From: [REDACTED]
Sent: 13 June 2022 15:06
To: Salam, Kabier - Oxfordshire County Council
Cc: Kelvin Pearce; [REDACTED]; James Griffiths; Emma Lancaster; Johnathan Welton; Caroline Ford
Subject: AXIS J9, HOWES LANE, BICESTER – PHASE 3
Attachments: 211014 - Planning Response CDC Land Drainage (1).pdf; 220203 - Planning Response CDC Land Drainage (2).pdf; 220406 - Planning Response CDC Land Drainage (3).pdf; 220506 - Planning Response CDC Land Drainage (4).pdf; S1209 - PH3 - 02G - Phase 3 SW Drainage Layout.pdf; S1209 - PH3 - DD01C - Phase 3 Drained Areas.pdf; S1209 - PH3 - 06 - Phase 3 Swale 1 Details.pdf; S1209 - PH3 - 07 - Phase 3 Swale 2 Details.pdf; S1209 - PH3 - DD05 - Construction Phasing Plan.pdf

S1209/220613em/WB/LDD

**Re: AXIS J9, HOWES LANE, BICESTER – PHASE 3
PLANNING APPLICATION NO 21/03177/F**

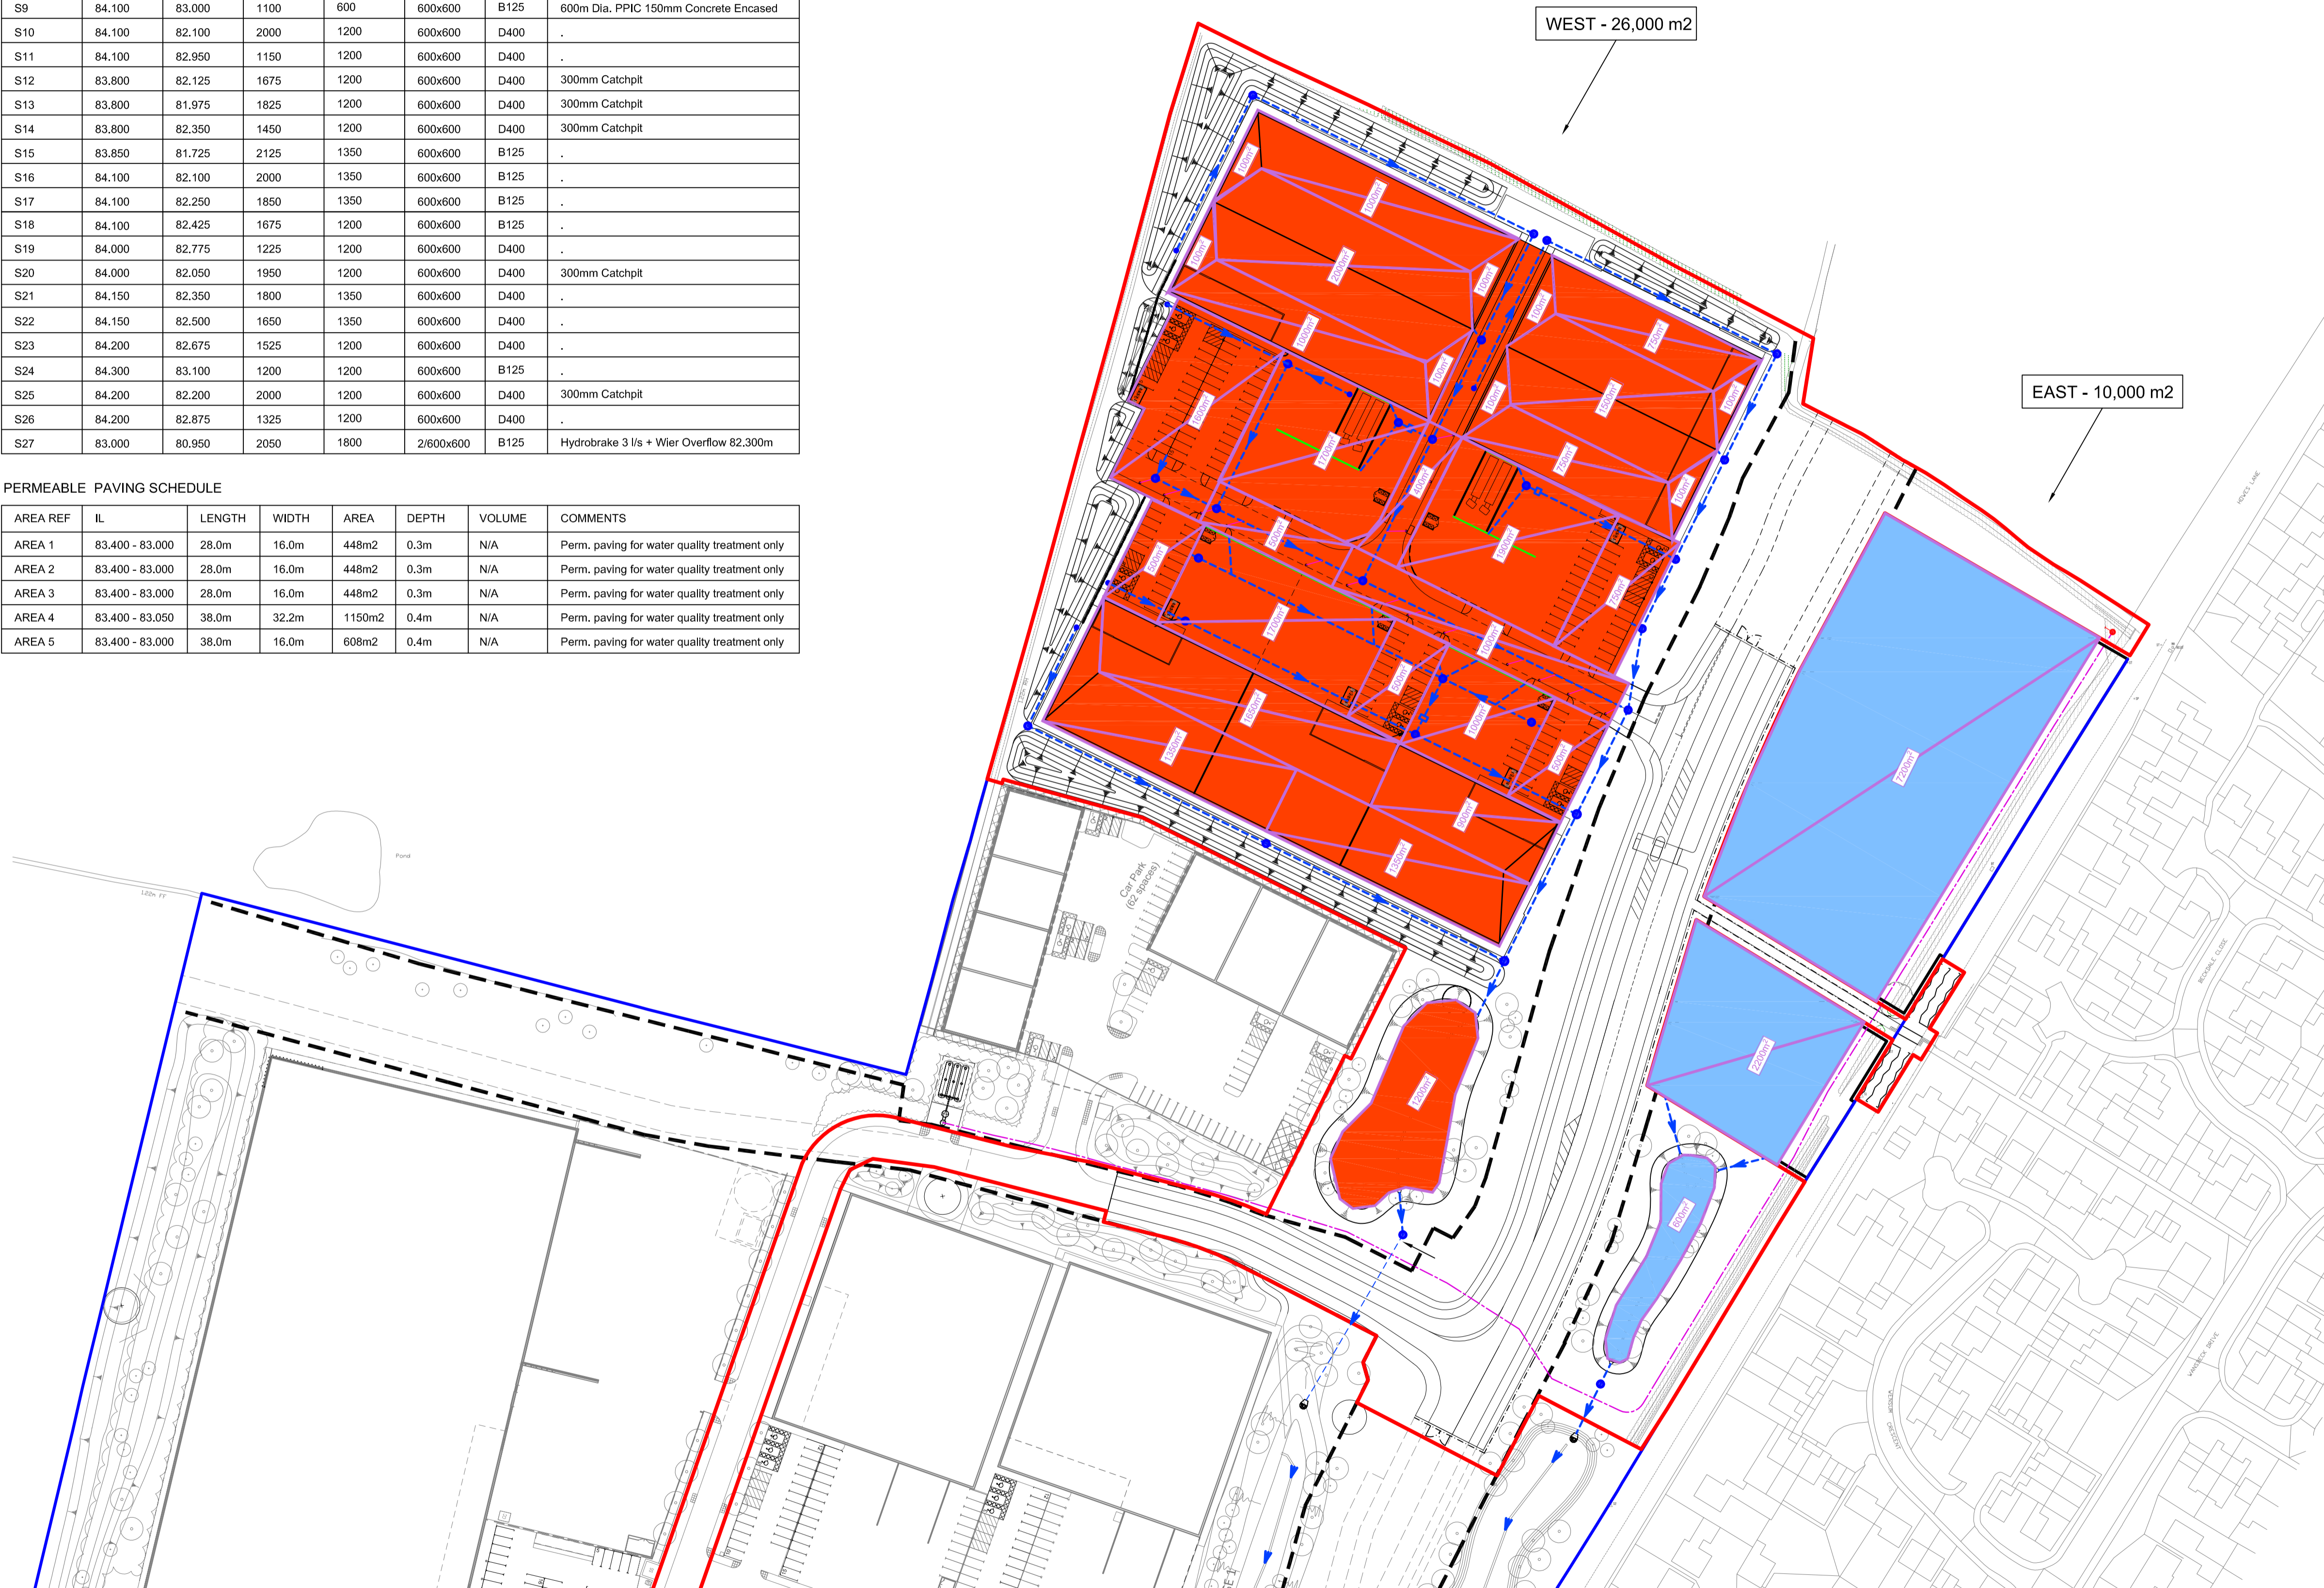
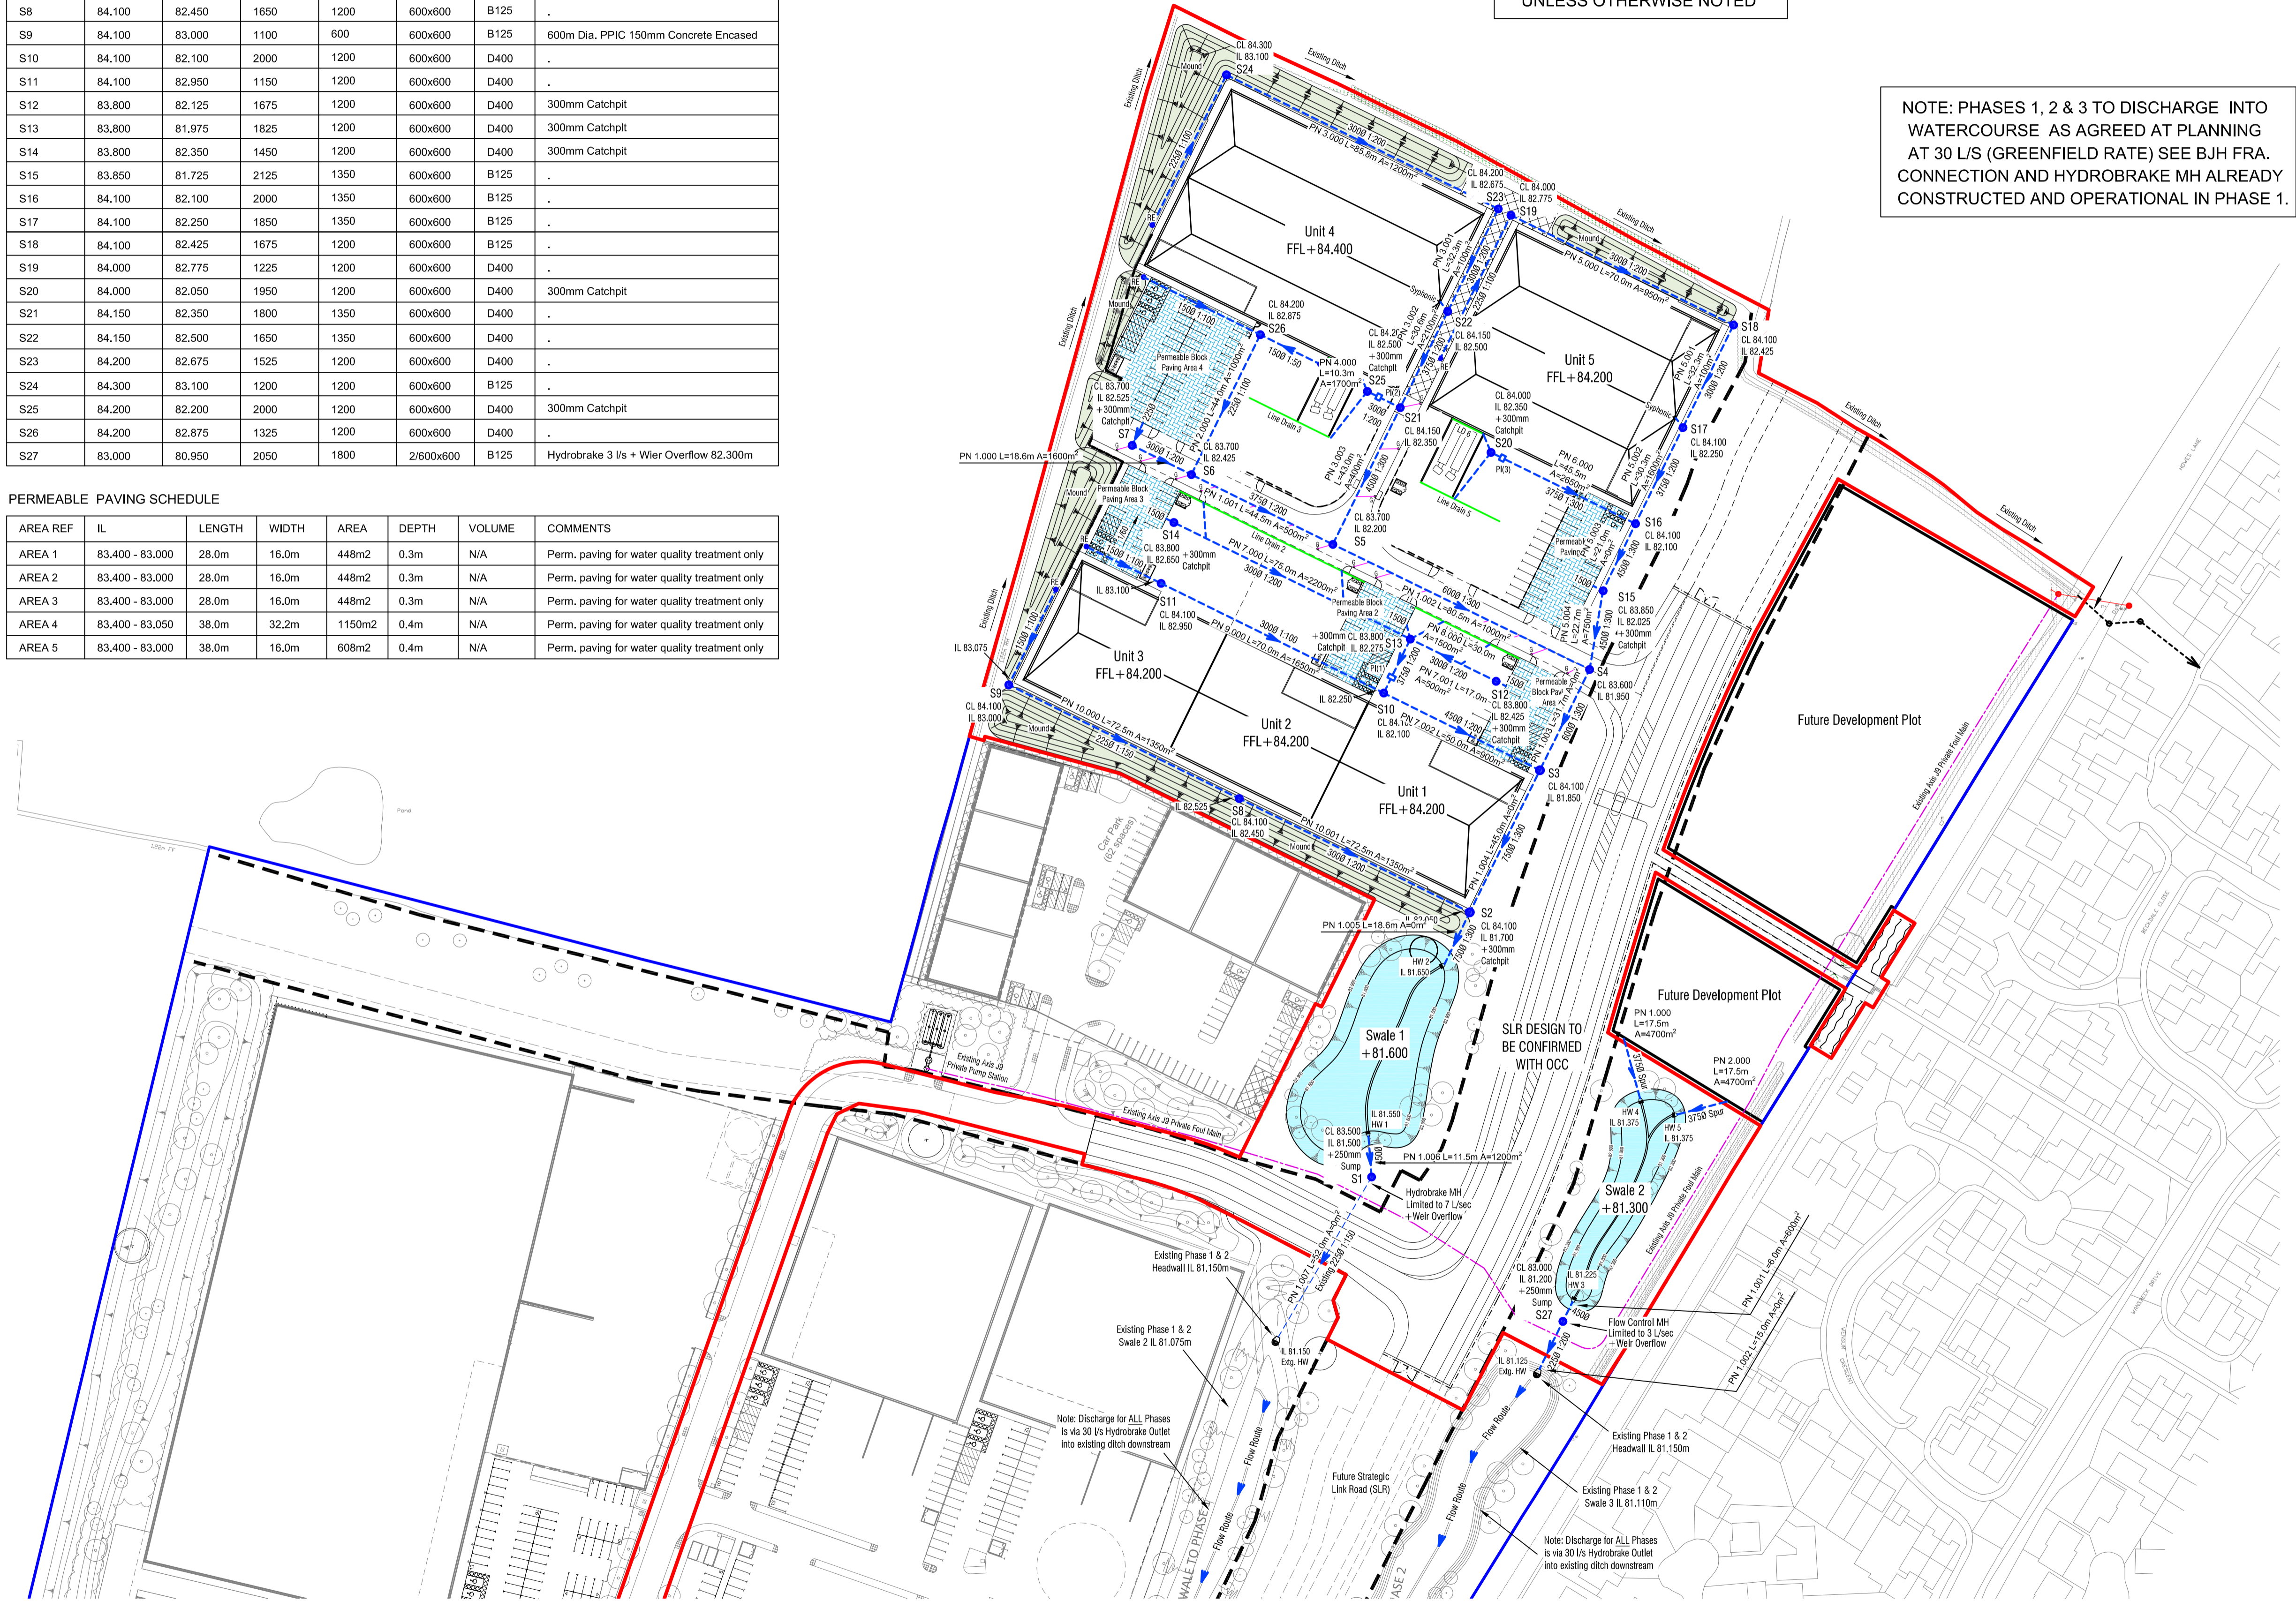
- **SURFACE WATER CATCHMENT PLAN**
The new Main Roads are to drain into linear Swales to each side of the SLR in order to reduce outlet to “Greenfield Flow Levels”.

The Main Road outlet is into the existing ditch alongside Howes Lane as pre the existing Drainage Regime.

Our revised Drawings S1209-PH3-02G and S1209-PH3-DD01C are now attached to clarify.
- **DRAINAGE STRATEGY WITHIN APPLICATION BOUNDARY**
 - Units 1, 2, 3, 4 and 5 will be drained into Swale 1.
 - The SLR/Bus route will drain to the existing ditch alongside Howes Lane.
 - Future development will drain into Swale 2.
 - I attach enlarged Plans of Swales 1 and 2 to clarify, Drawings numbered S1209-PH3-06 and S1209-PH3-07.

**Construction Phasing Plan 1:1000**

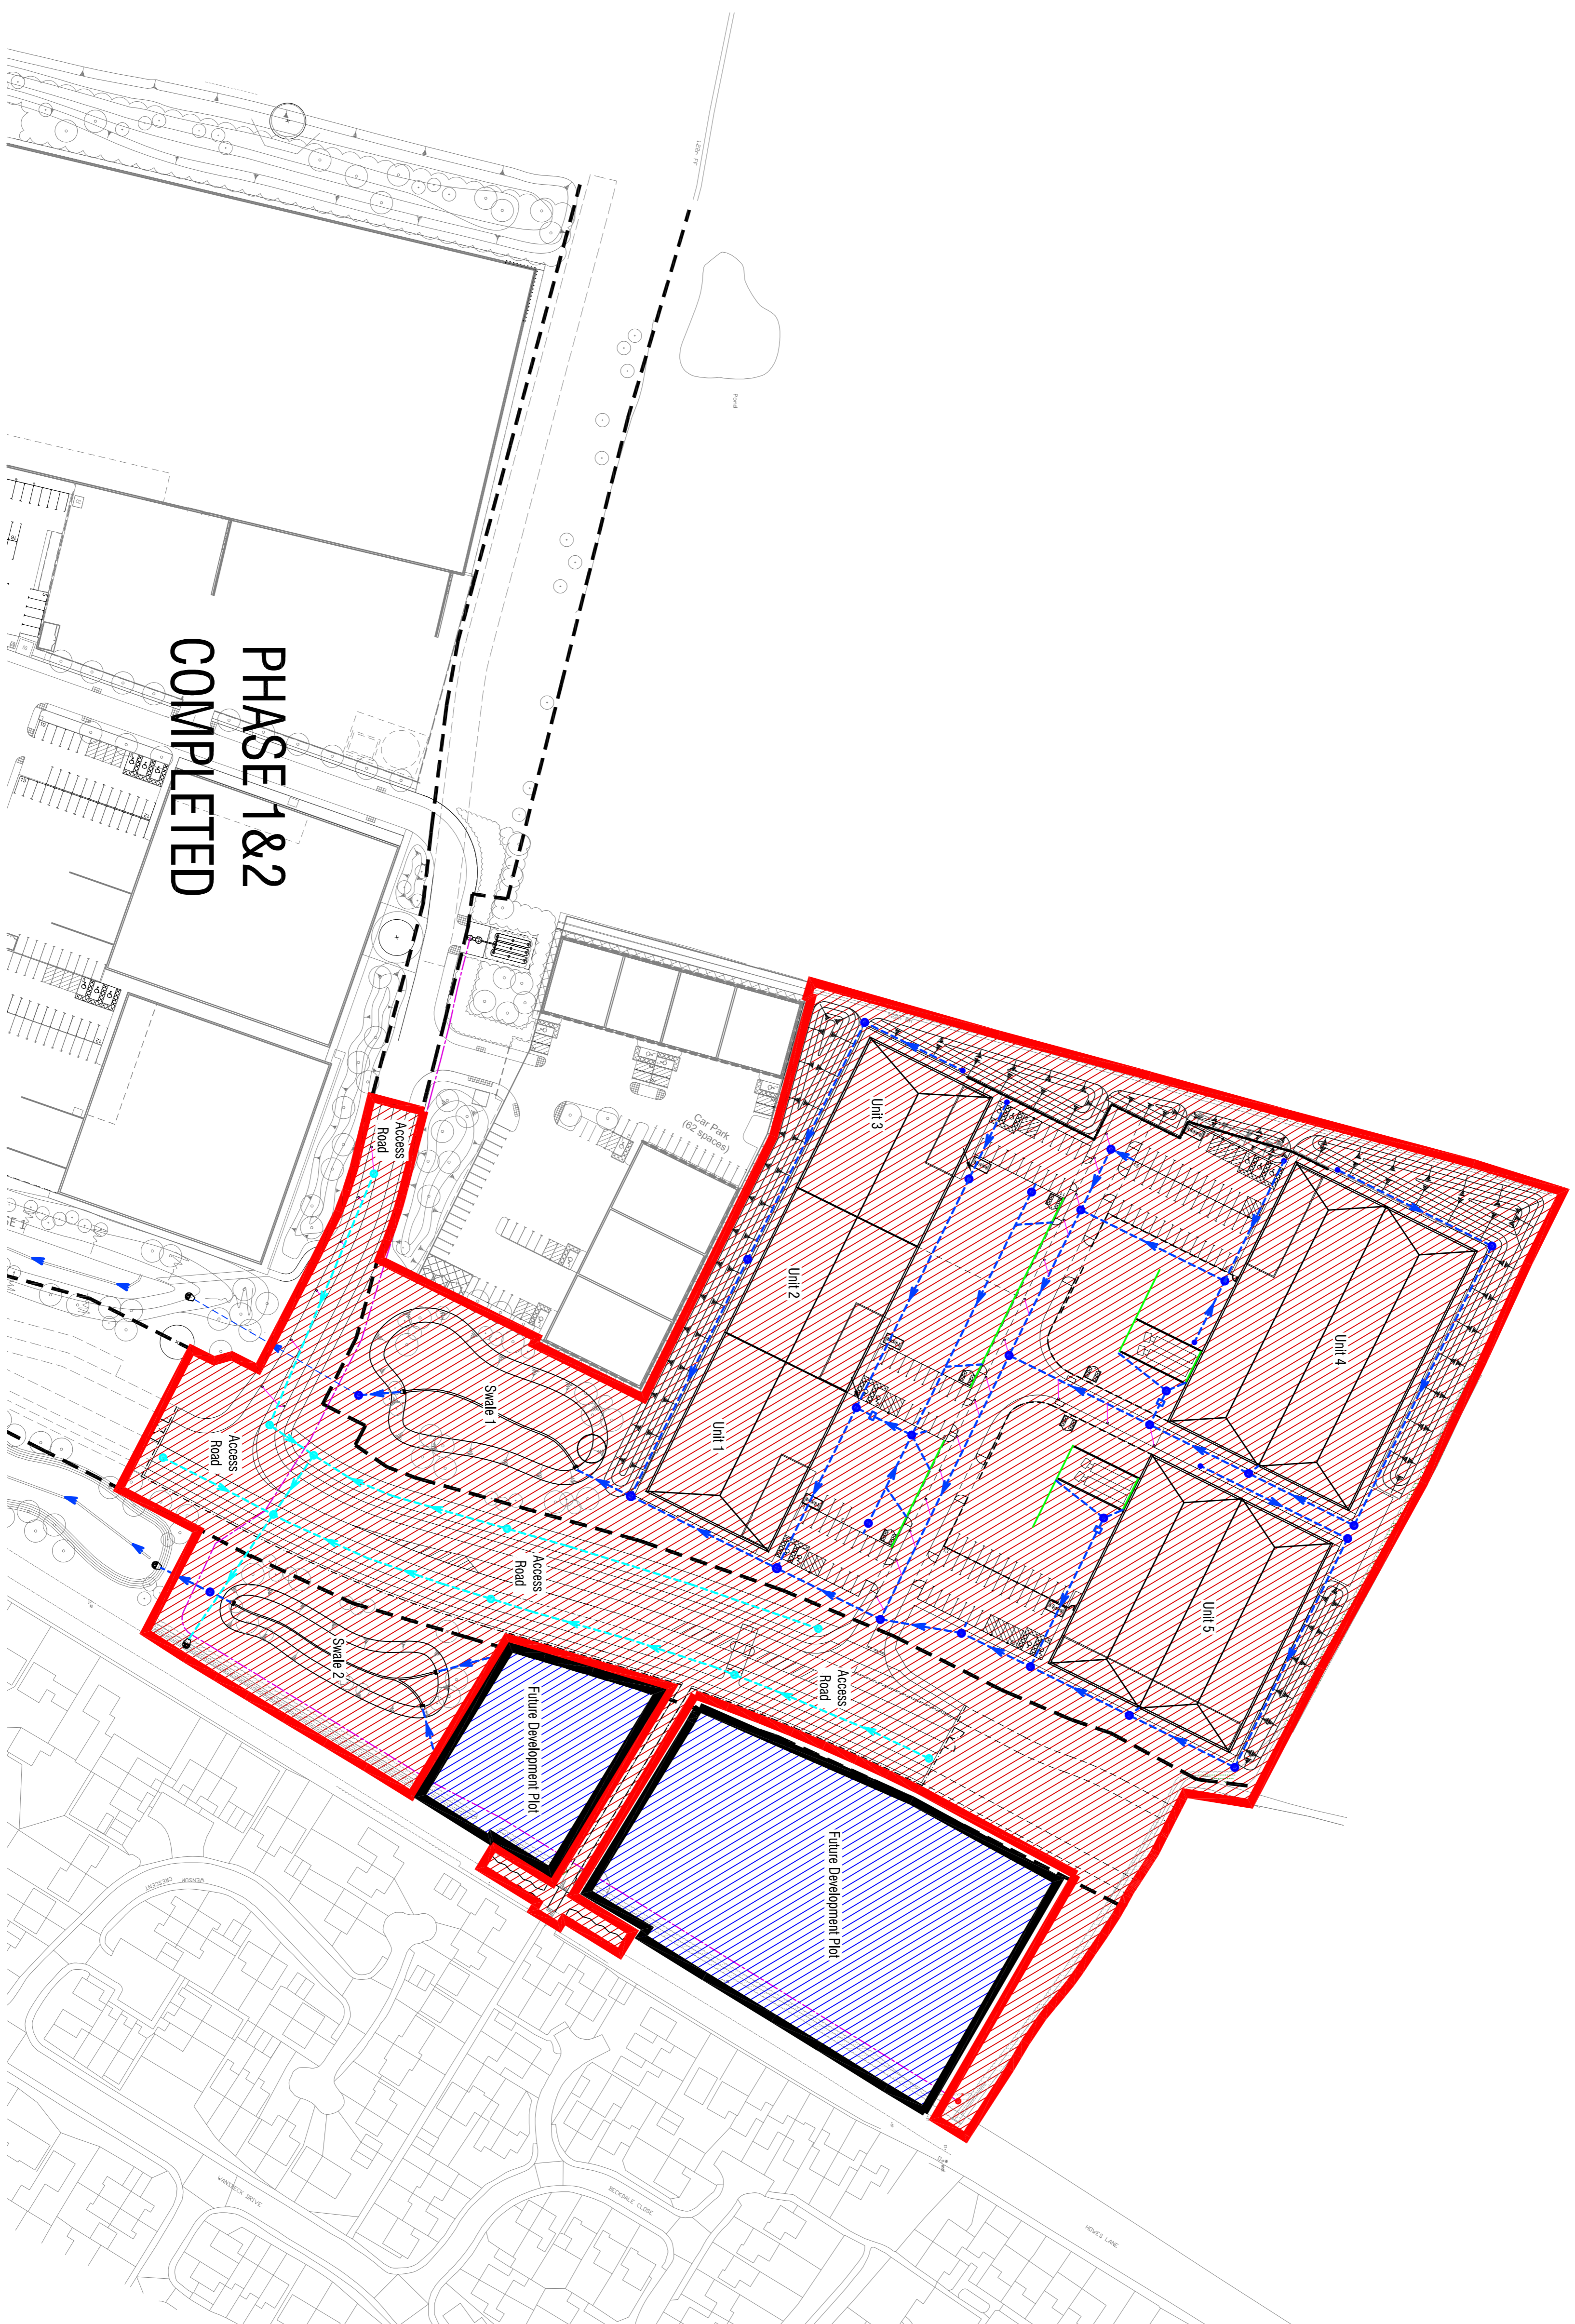
- PHASING PLAN

I attach a simple Phasing Plan numbered S1209-PH3-DD05 to assist and clarify.
